WAYNFLETE LOWER SCHOOL - ADDENDUM #4 [post bid]

date: Friday, March 31, 2017
project: Waynflete Lower School Addition & Renovations, 2013-0050
prepared by: Austin Smith Scott Simons Architects
to: Cordelia Pitman Wright Ryan Construction
Rick Bergeron Wright Ryan Construction
Luke Dione Wright Ryan Construction
Anne Hagstrom Waynflete School
Patrick Boure Waynflete School
Phil LaClaire PML Project Management

Subject: Addendum #4 to Bid Documents of January 12, 2017

A528

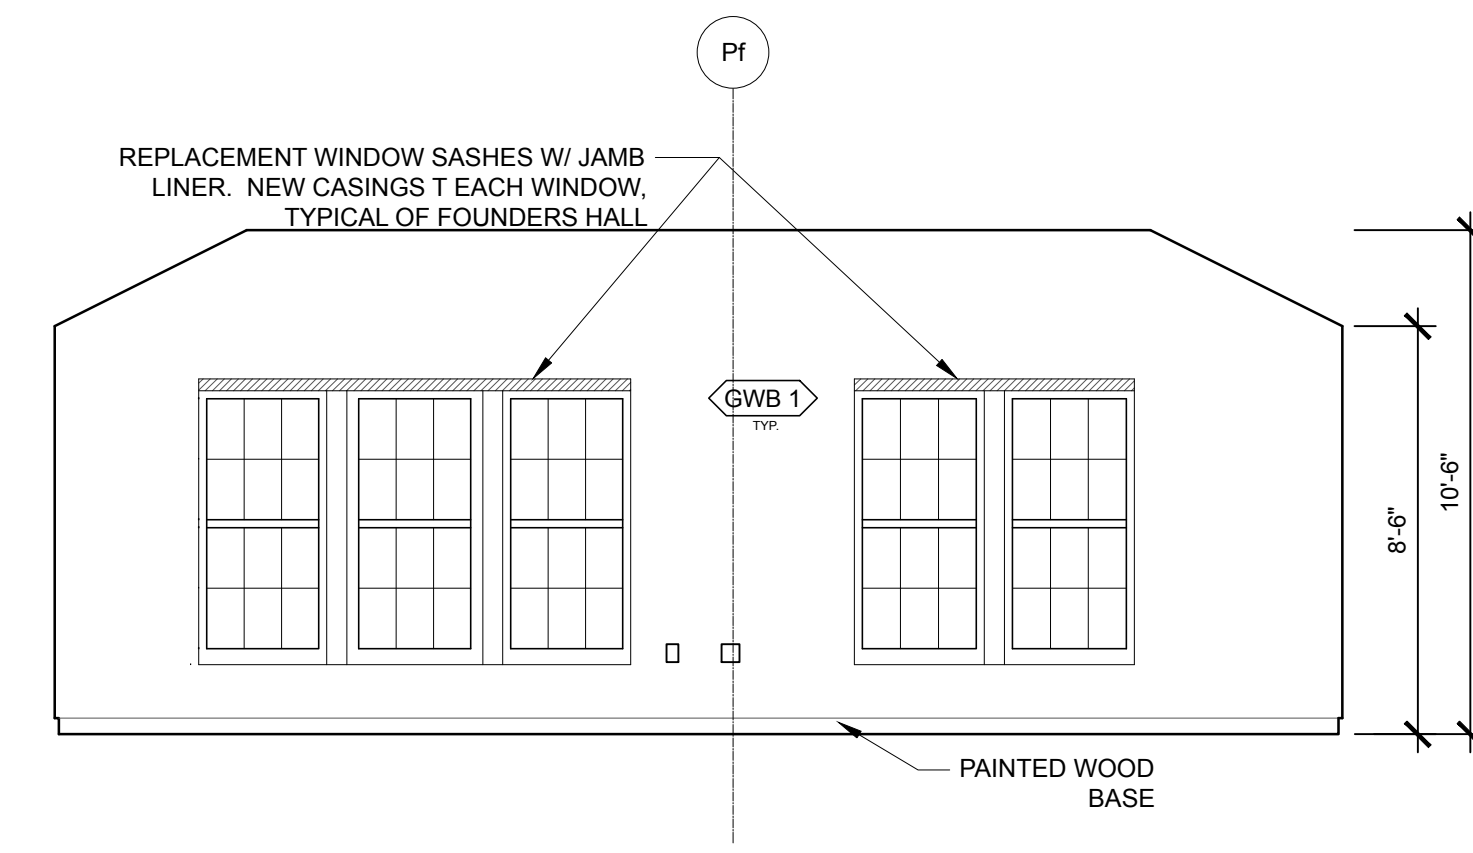
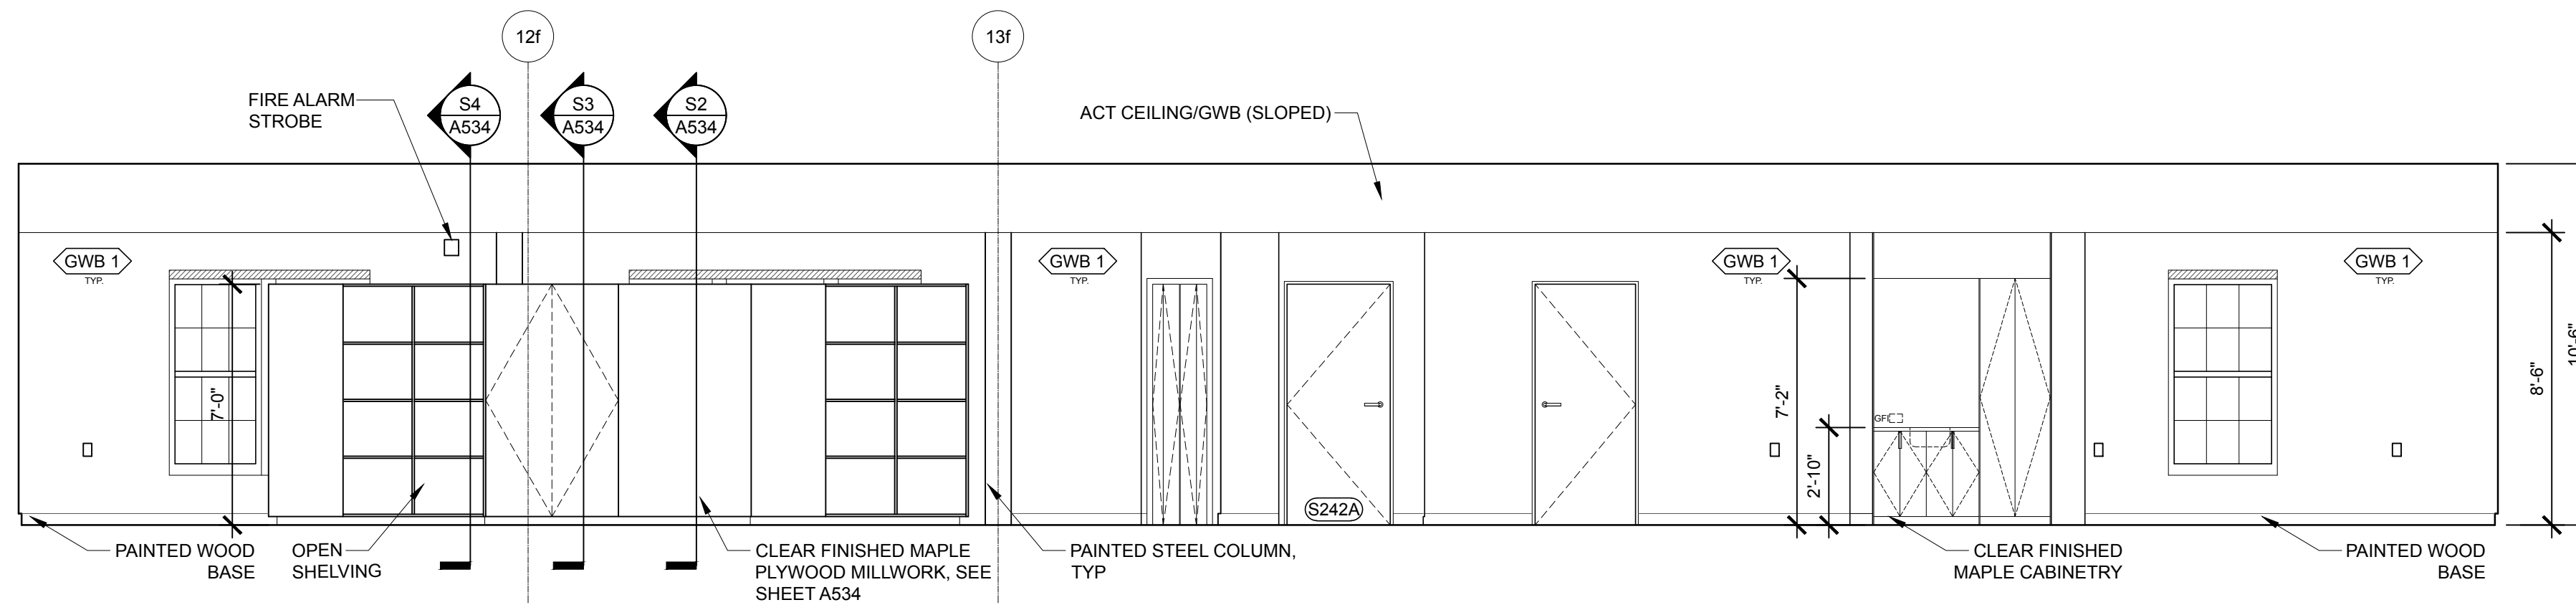
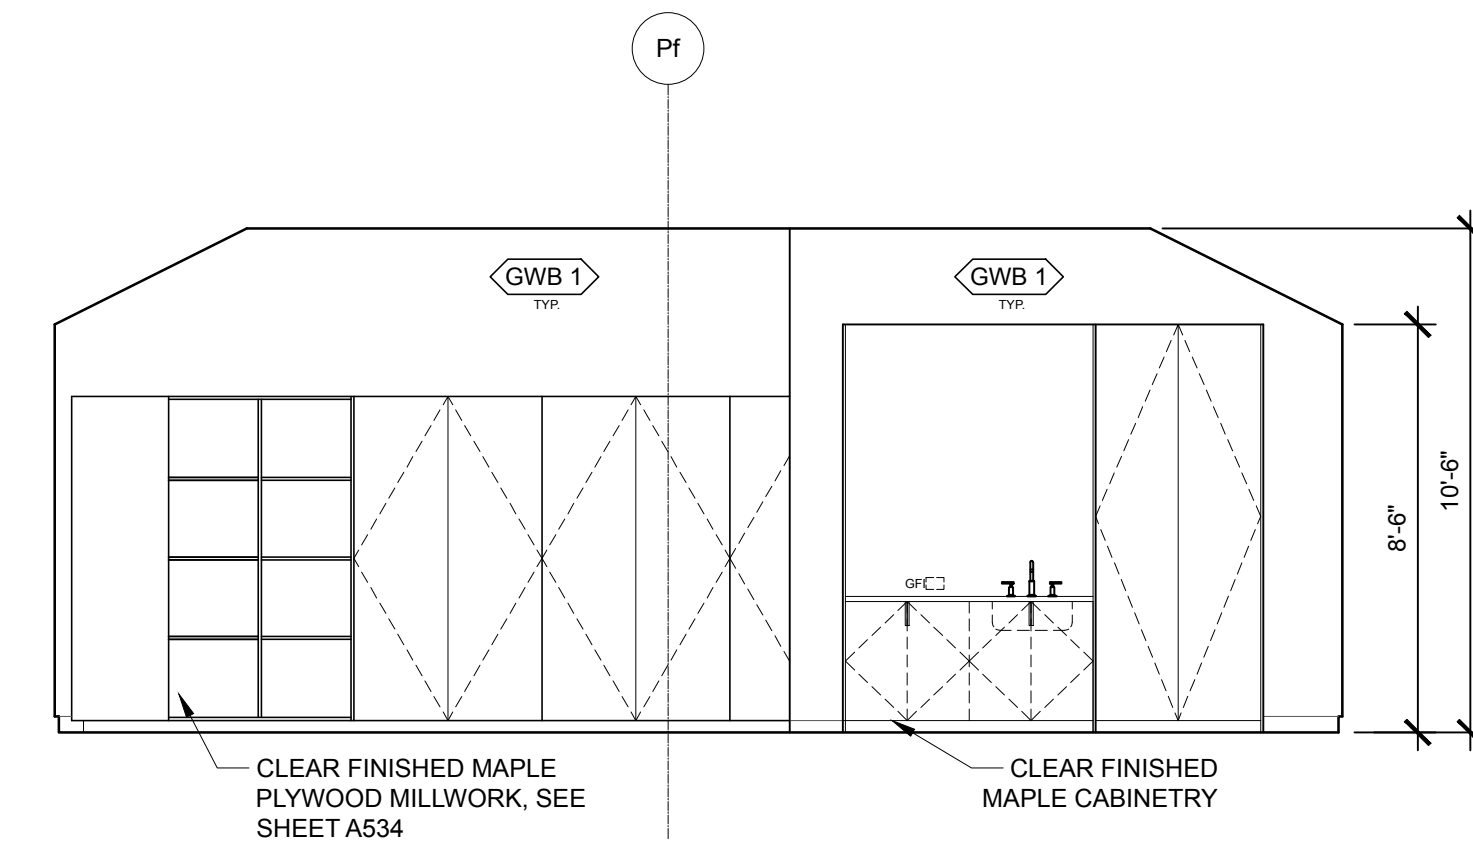
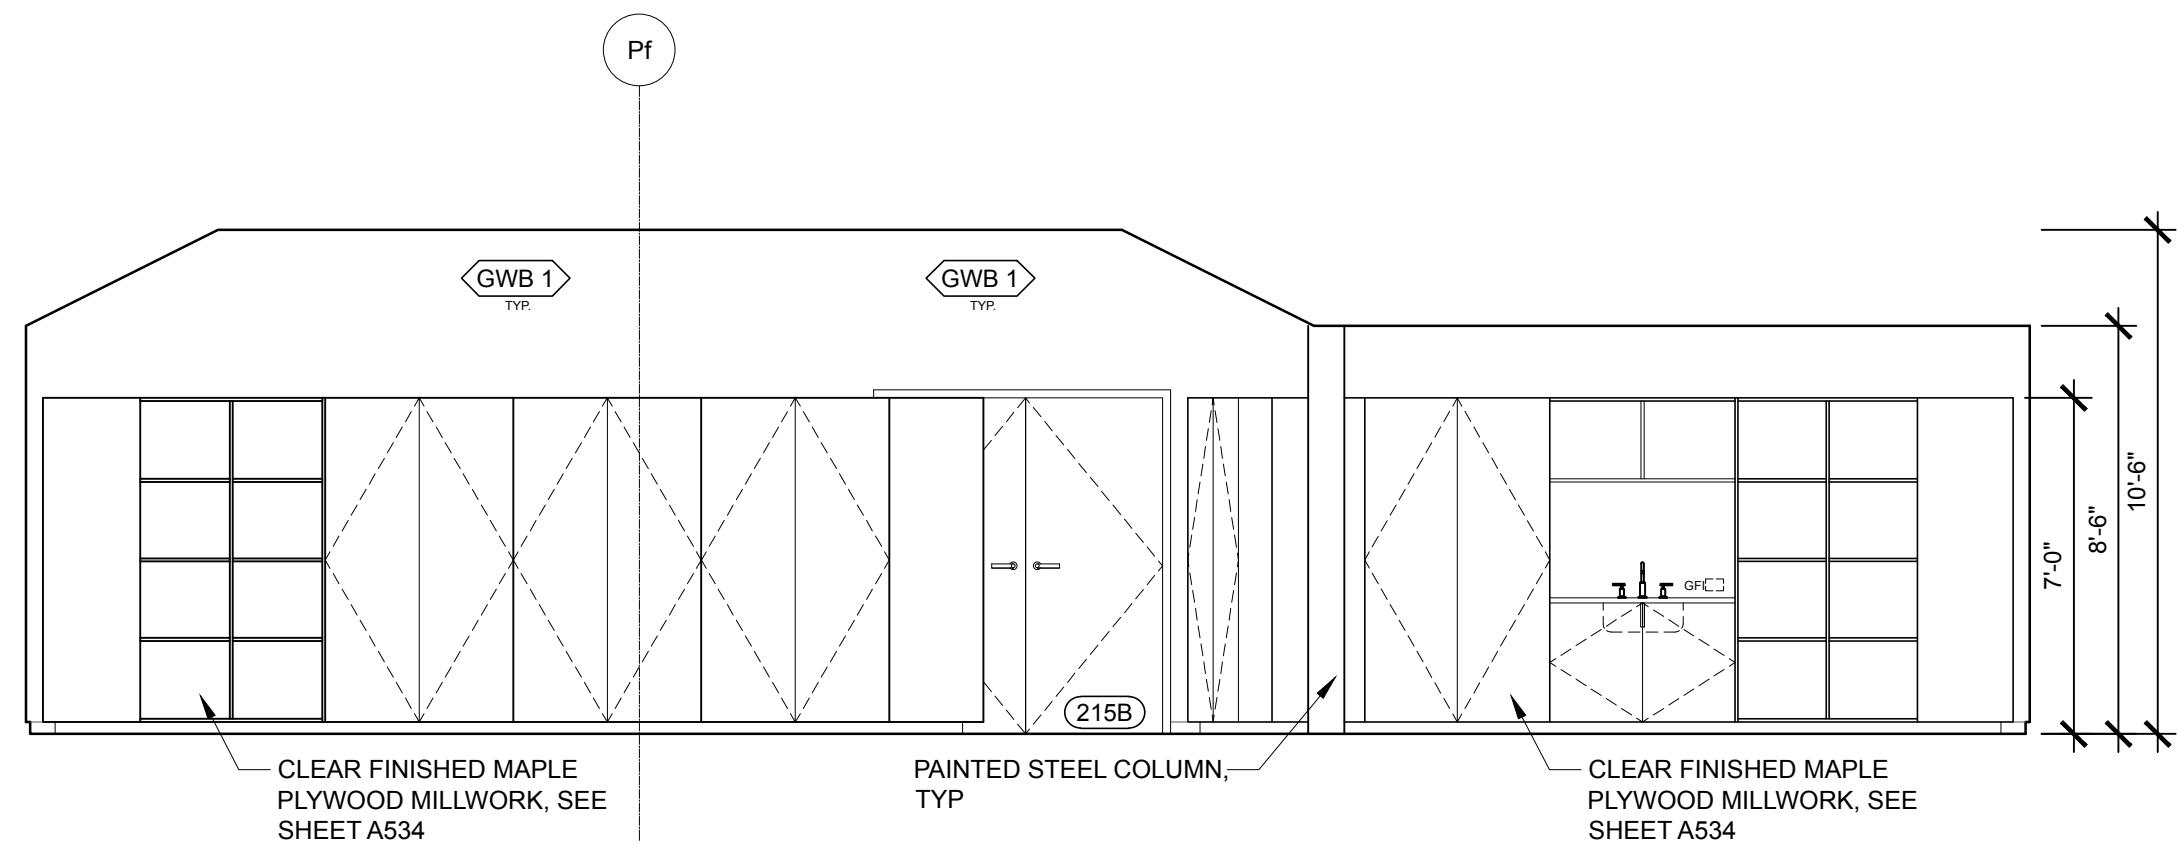
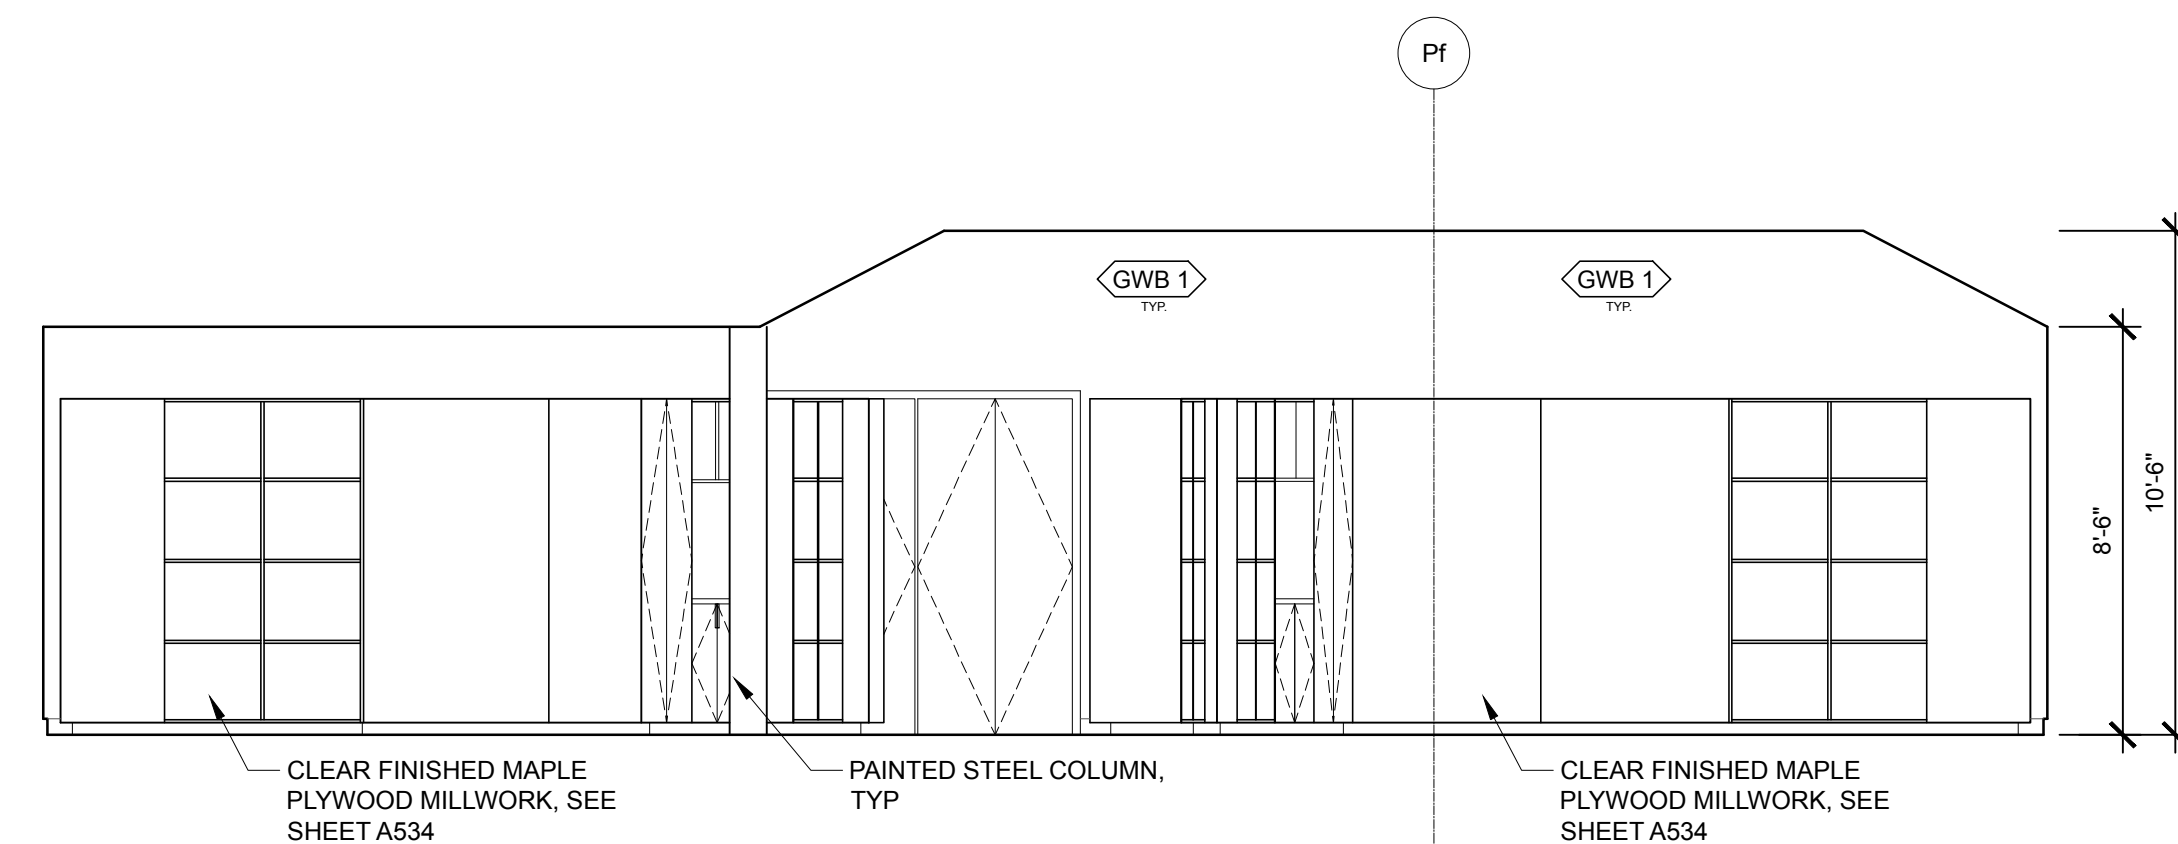
- 4-D1 Sheet A131 At "Exterior GWB Soffit" Note:
Add: ": Provide level 5 finish skim-coat over sheathing, typical. Provide V-groove vinyl trim at control joints"
- 4-D2 Sheets A523,
A525
A536
A528 At classroom interior elevations all instances of this note:
Delete: "Dry erase paint surface, final extents to be coordinated w/ architects"
- 4-D3 Sheet A601 Under General Notes related to the Door and Frame Schedule:
Add: "5. All paired doors with combination 3'/2' doors, the 2' leaf shall be inactive with use of egress hardware"
